CITY OF ALBUQUERQUE

October 24, 2017

**RE: Industrial Water Engineering
Conceptual Grading and Drainage Plan
Engineer's Stamp Date 10/19/17
Hydrology File: C16D006LL**

DRAWING NAME
**GRADING &
DRAINAGE PLAN**
SHEET NO.
CG-101

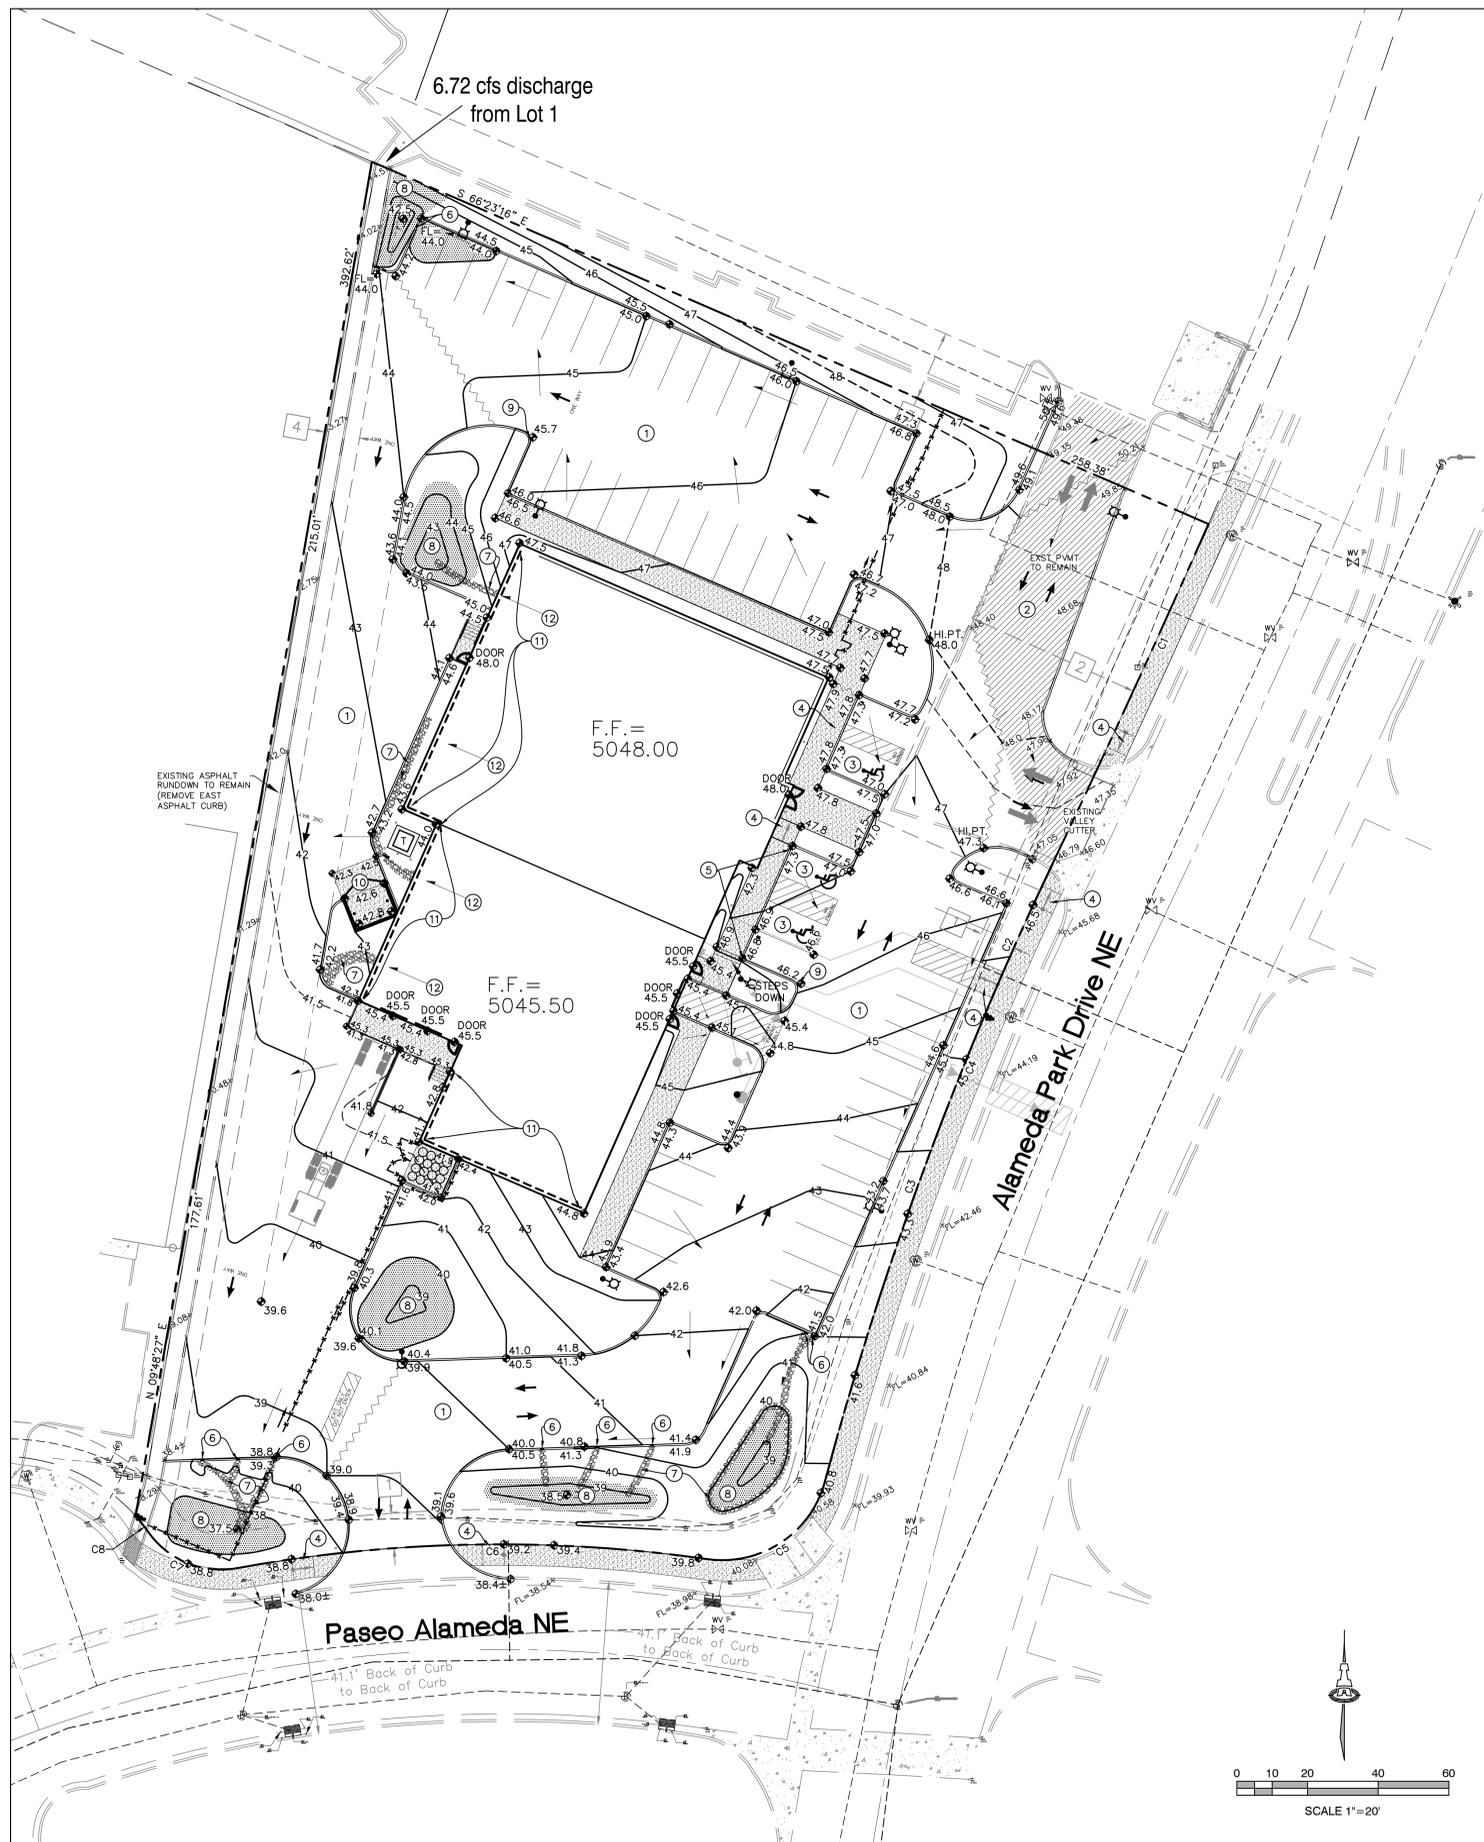
2. Call-out top of pond, bottom of pond, and volume on sheet CG-101.

1. Correct text size on callouts to be 0.10" or larger; this applies mostly to the survey info for the water valves, drop inlets, and storm drain.
